DEVIATION REVIEW AND DECISION FORM

Deviation No. 3
REV. 3-14-2019

Subdivision or Project Name: Rollin' Ridge Estates

Section of ECM from Which Deviation is Sought: 2.3.7.E Intersections - Turn Lane Design

C1.3

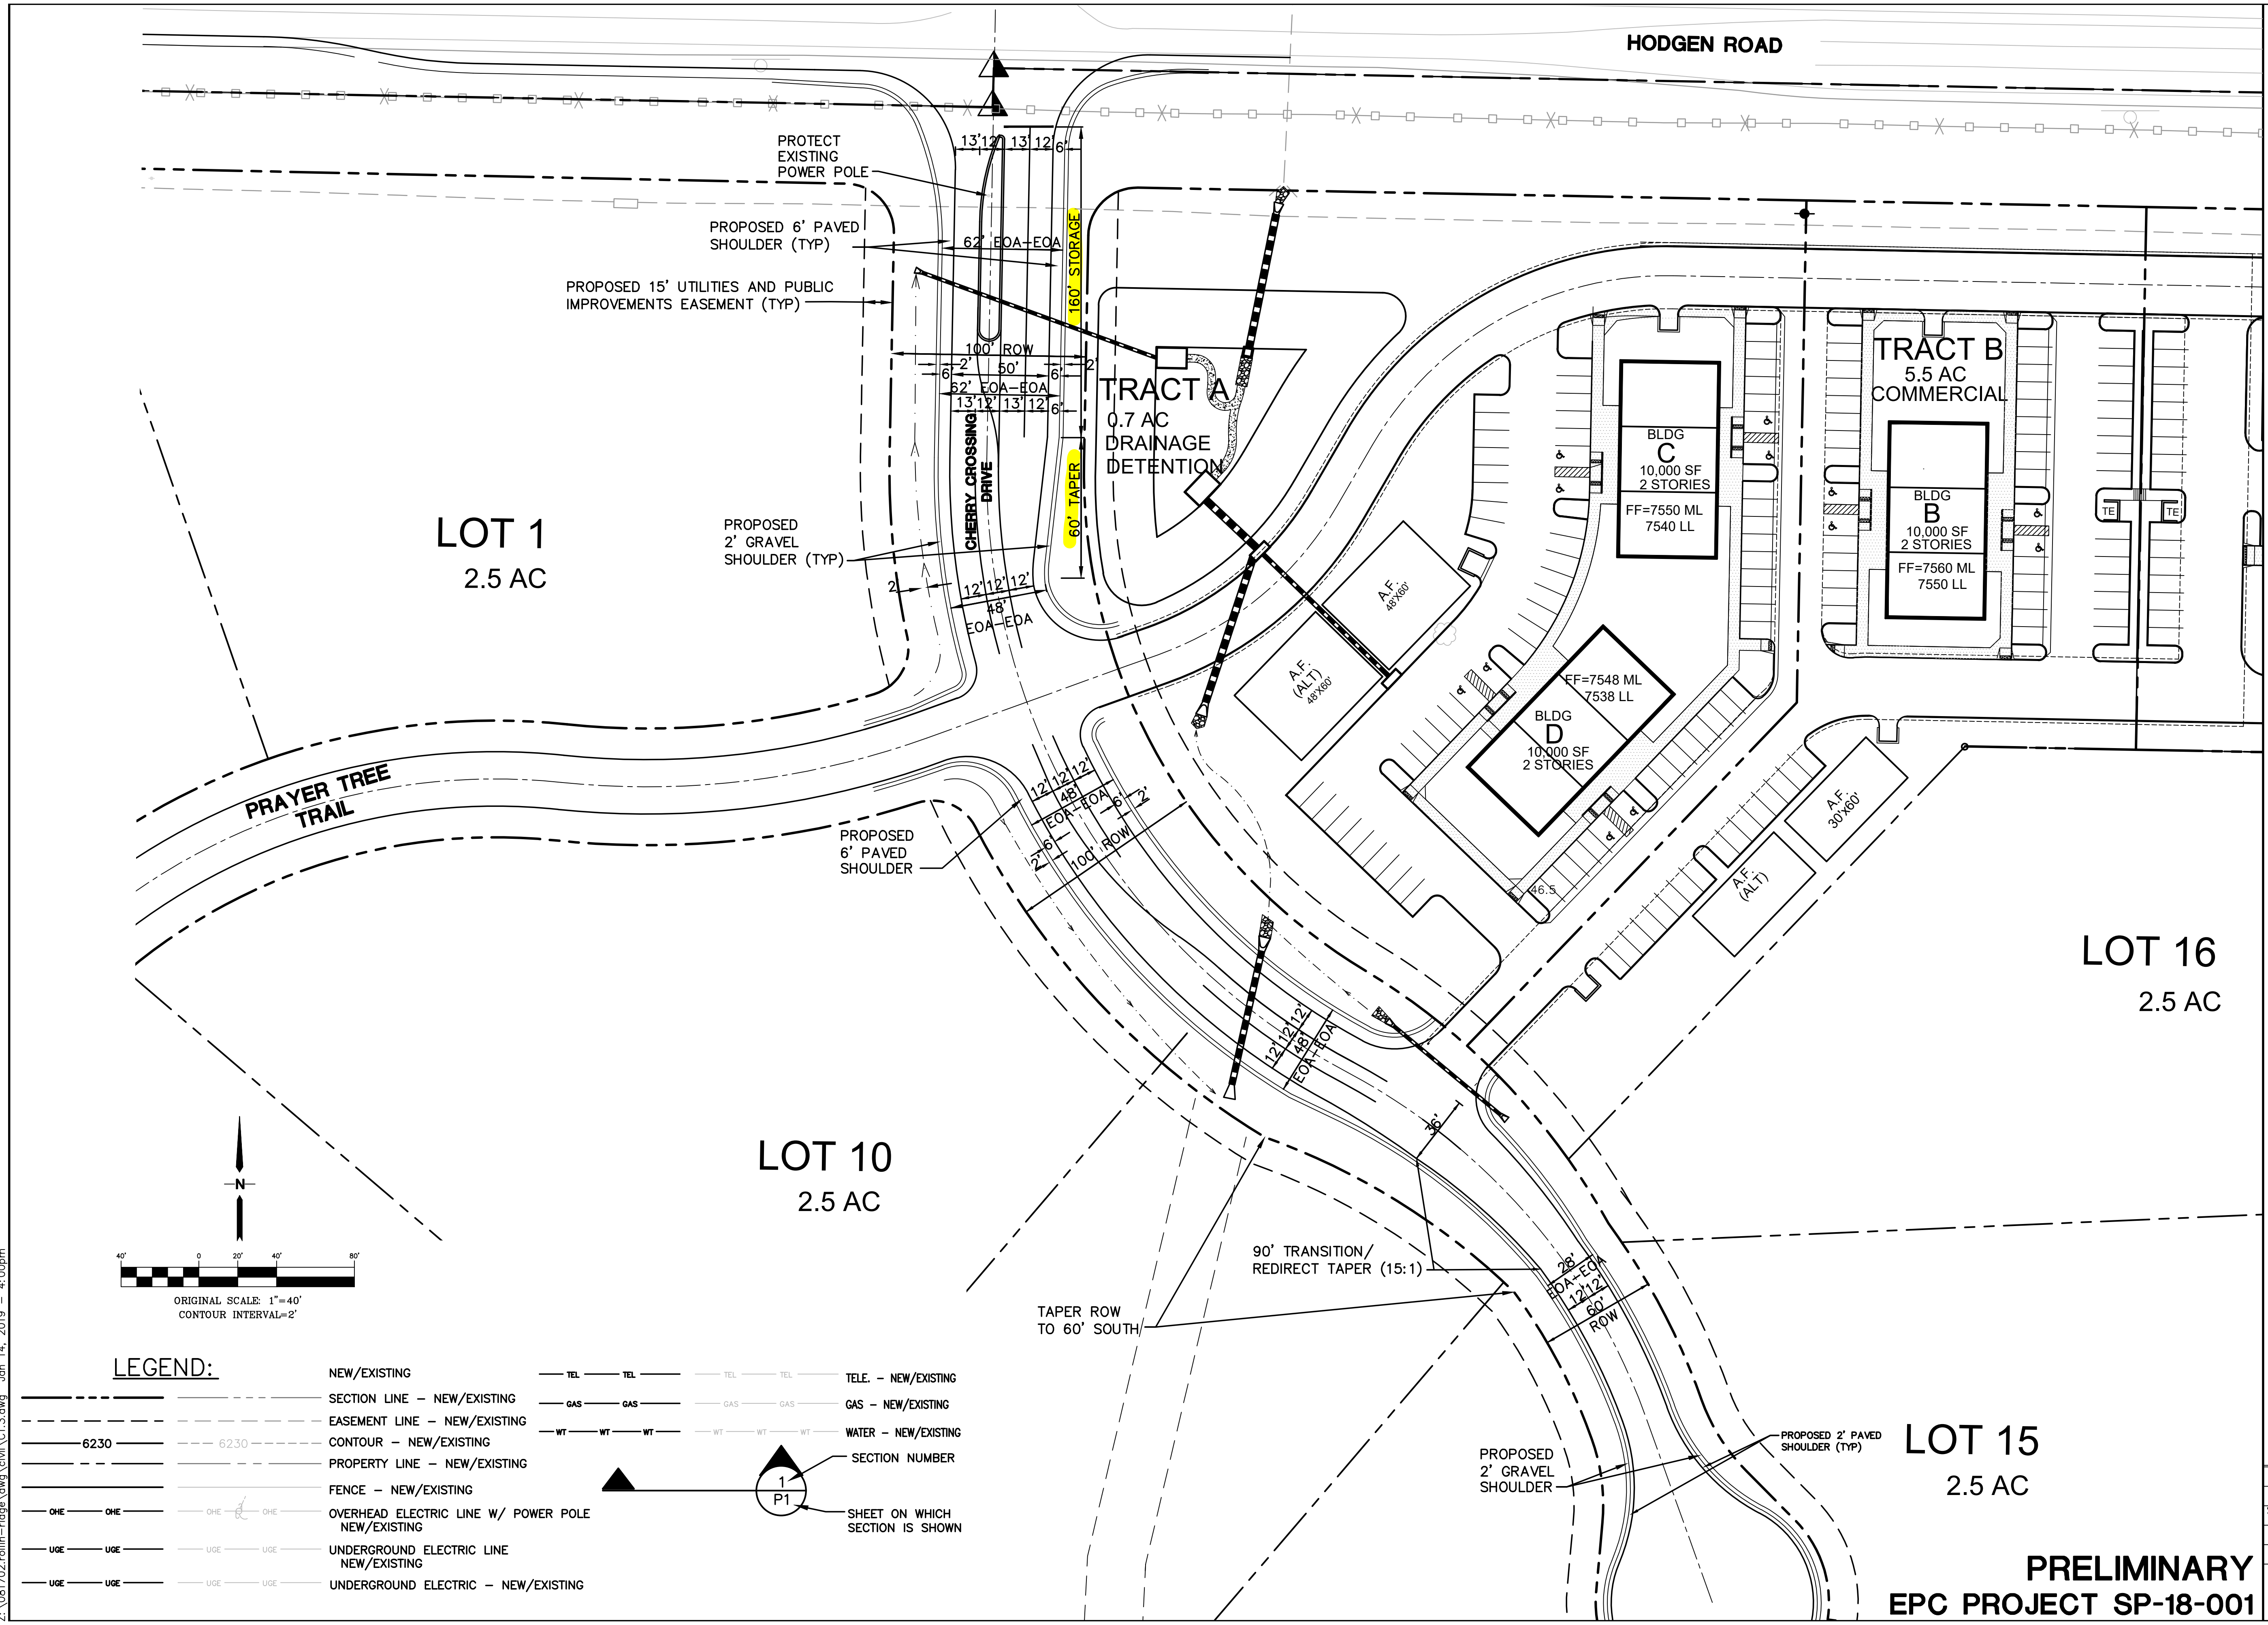
Original comment requested to remove references to the TIS, EXCEPT WHERE EXHIBITS ARE NEEDED TO CLARIFY THE DEVIATION. Please put the exhibit back into this request.

if it makes this dev easier to understand, please put this exhibit in this document.
